Date: 24-Feb-2026
Our Ref: 2026/90249

**Application for a non-material amendment following a grant of planning permission,
Town and Country Planning Act 1990**

**Non material amendment to previous permission 2025/92605 for erection of stables
and garage and formation of riding manege
Upper Holme House Farm, Hirst Lane, Cumberworth, Huddersfield, HD8 8GA
Application Number: 2026/90249**

title General arrangement as proposed
number 21041D-02-P03
scale 1:100, 1:250
size A1

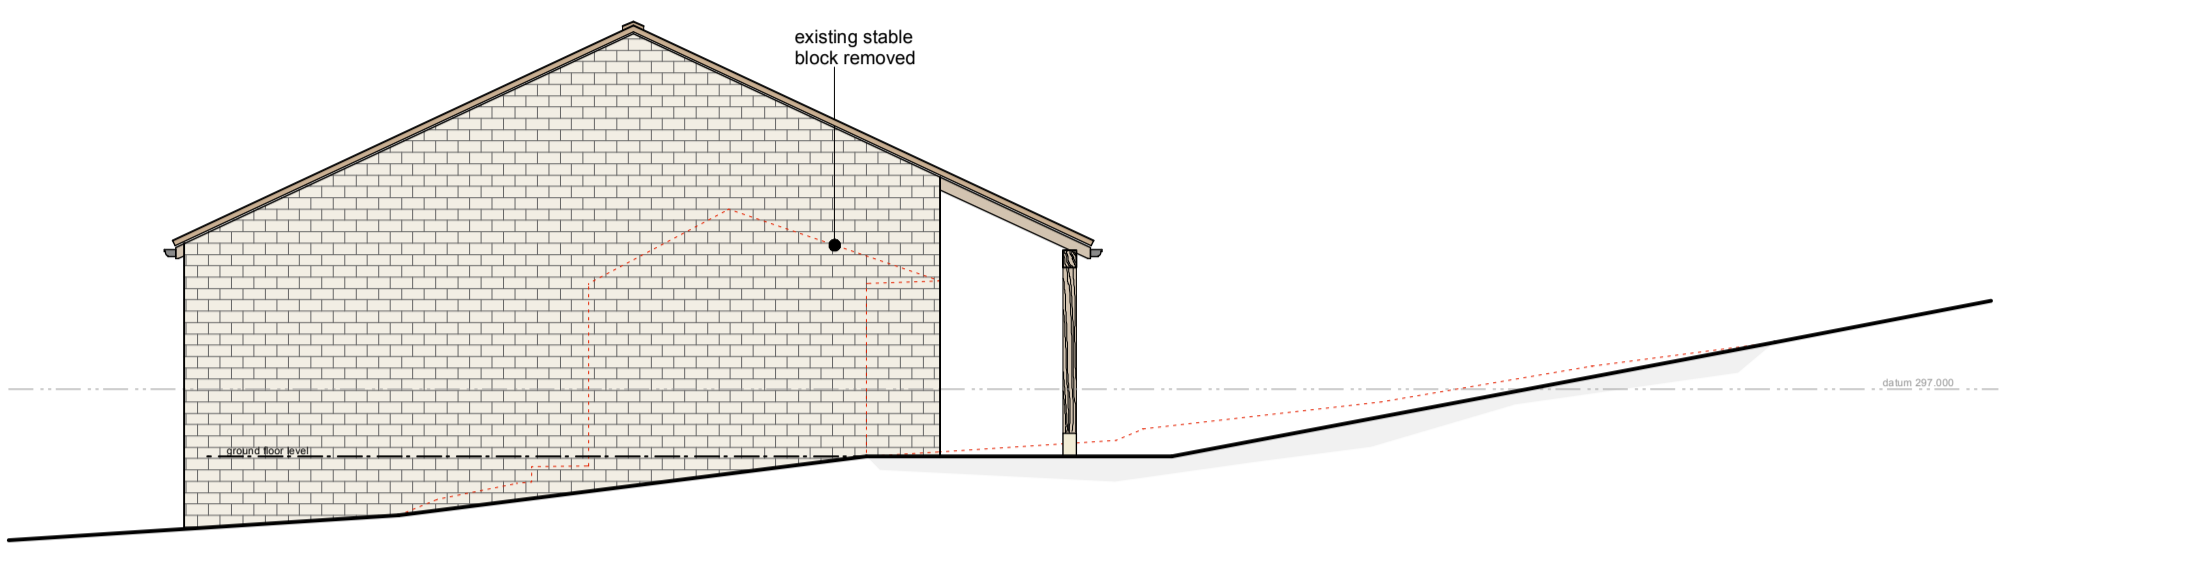
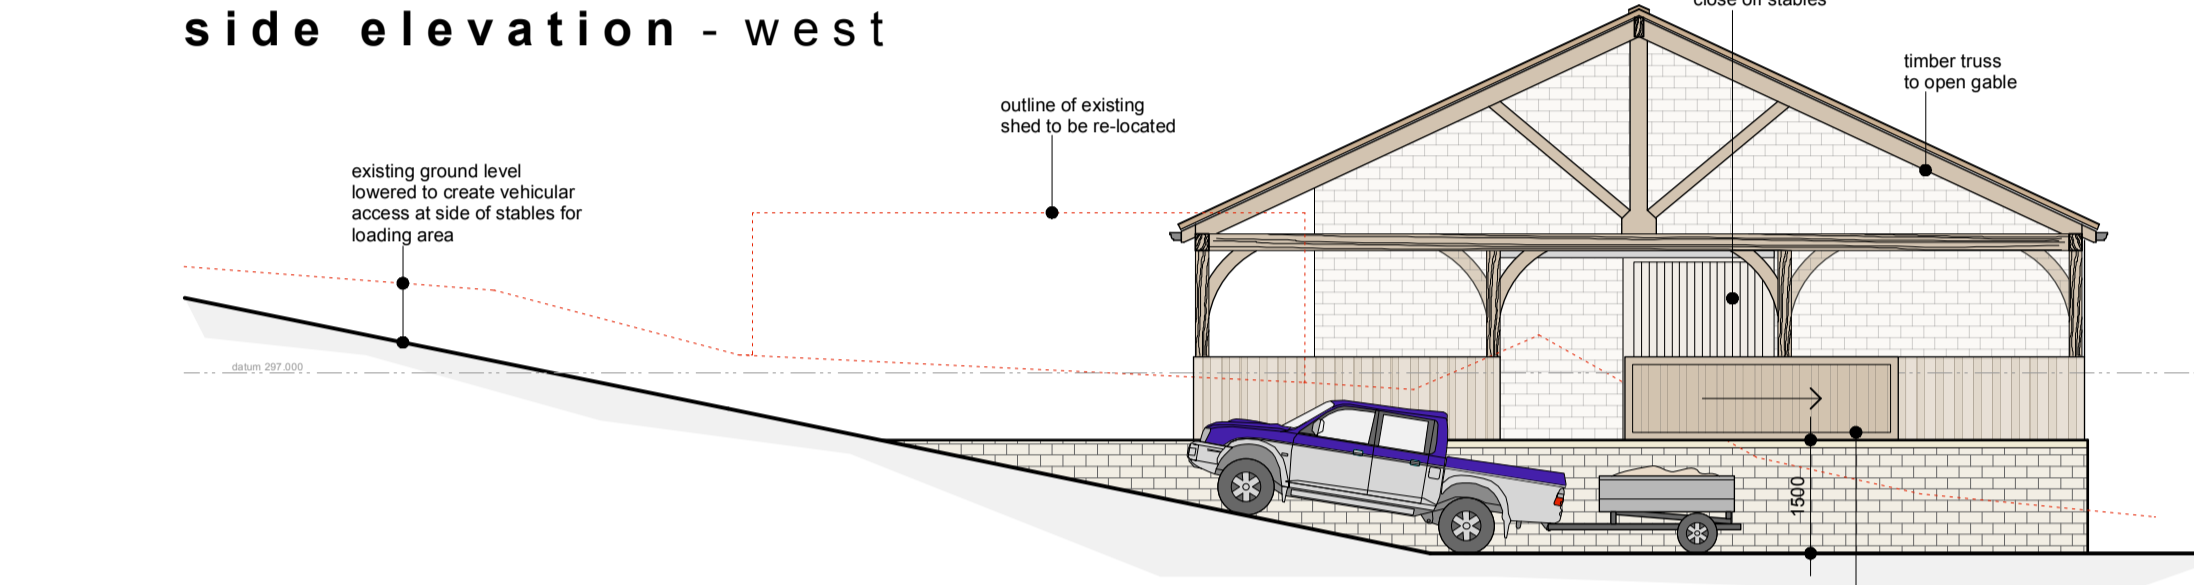
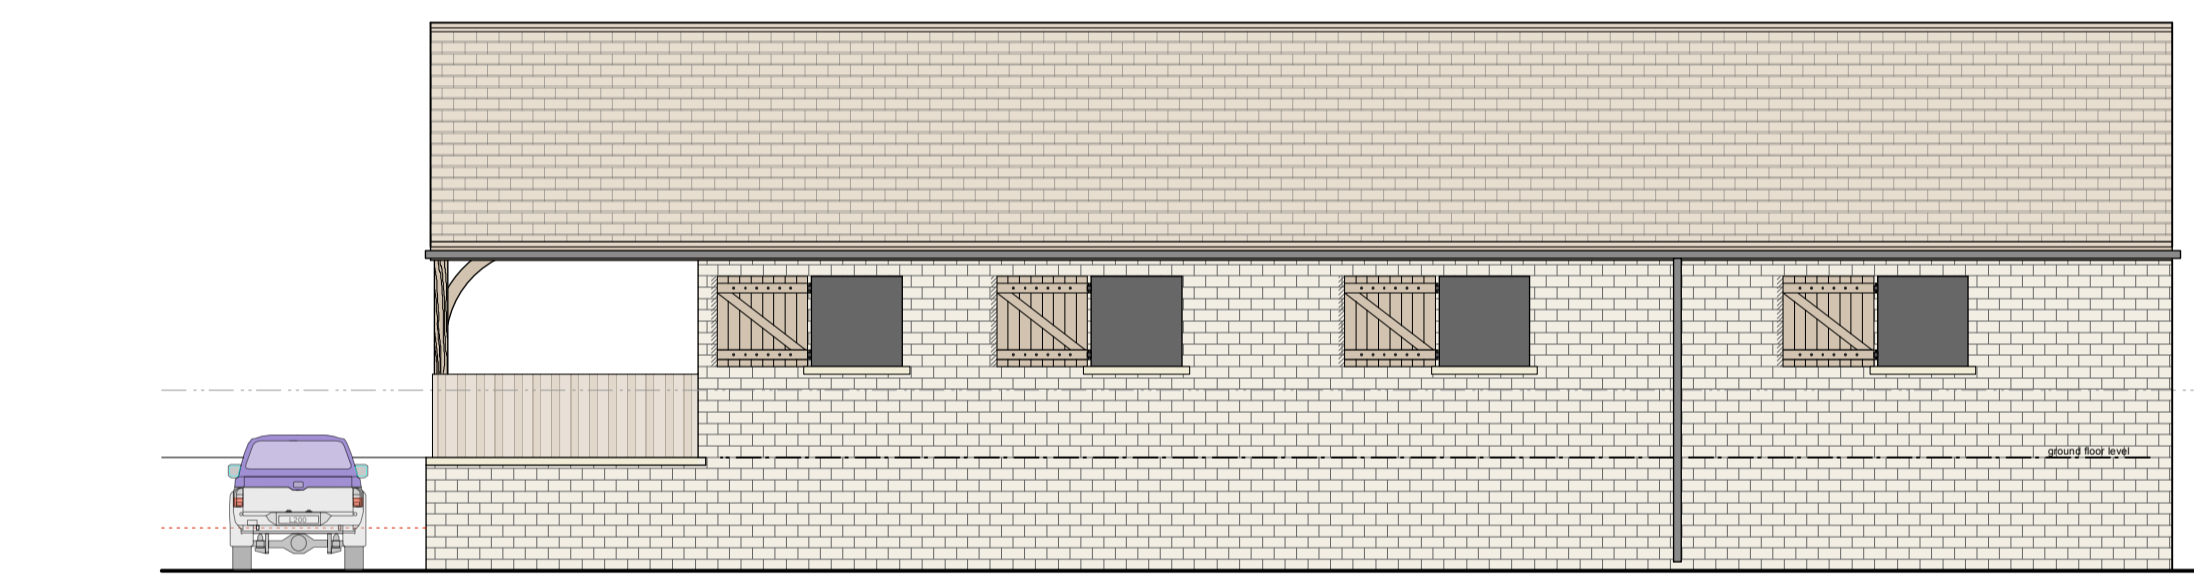
The amendment seeks to make alterations to the material palette of the approved stables/garage. The external walls would be constructed solely from natural stone. The plans indicate that the proposed amendments would significantly alter the external appearance of the structure. Therefore, given the scale of the changes, there is potential for harm to the visual amenity of the wider street scene. Furthermore, the proposed amendment would contravene Condition 3 of the original approval which states that the stable/garage building shall be faced in vertical timber boarding for the external walls with a natural stone base and natural stone slate for the roof.
